Our Ref: AB/125/20/L

Listed Building Consent for Alterations, Extension or Demolition of a Listed Building

Development: This application is a single storey, side extension to the rear of the building
To add a single storey flat roof extension to the side of the existing kitchen with a rooflight.
To remove an internal kitchen door and replace with an internal window.
To move and existing kitchen double door to the newly extended entrance.
To enlarge the entrance to the new extension by part removal of existing kitchen wall (140cm long)

Location: 19 Maltravers Street Arundel BN18 9AP

19, Maltravers Street, Arundel, West Sussex, BN18 9AP
Scale 1:200

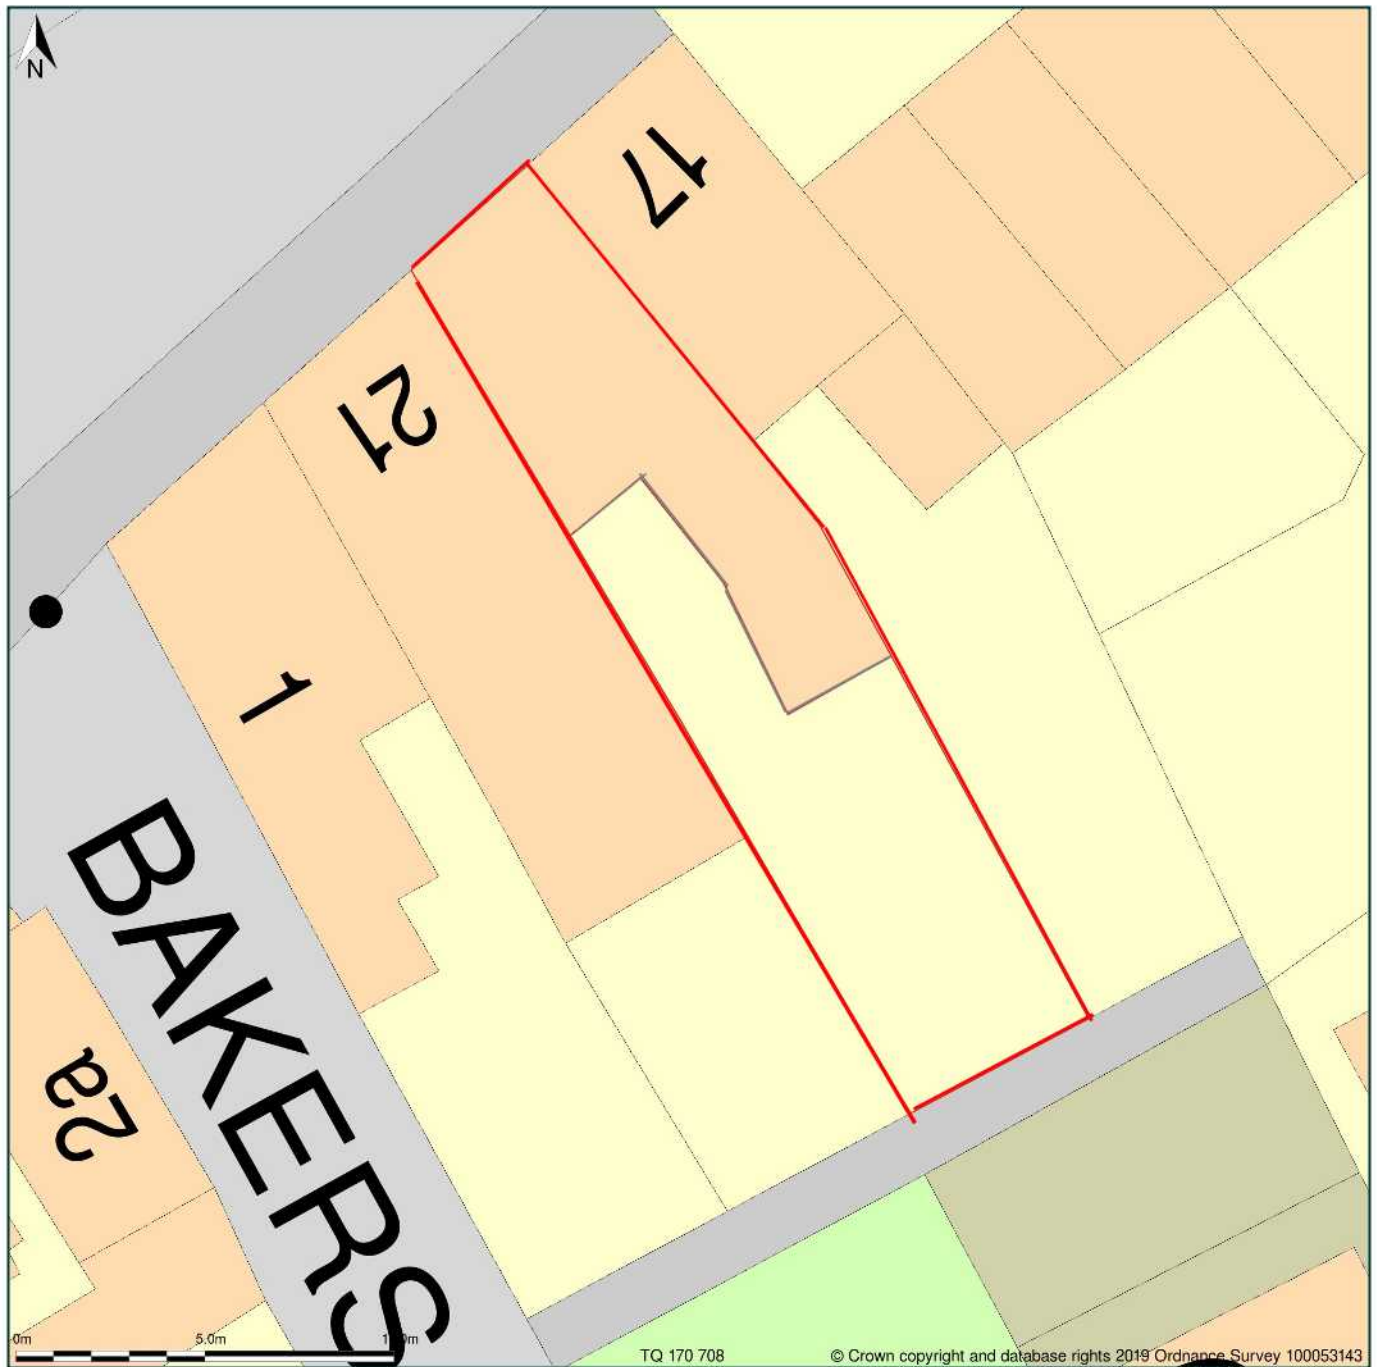
Block Plan

You are required to have clear dimensions from the proposed extension(s) to all site boundaries. Please amend.

Elevation view 19 Maltravers Street, Arundel, BN18 9AP

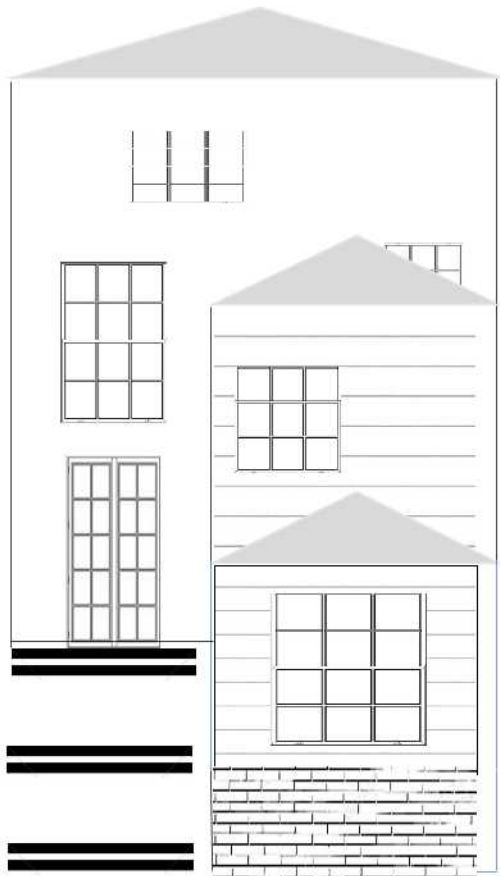
Elevations

Please submit 1 electronic or 3 paper copies of clearly labelled existing and proposed elevations at a scale of 1:50 or 1:100. Further details can be found in the Validation Requirements List.
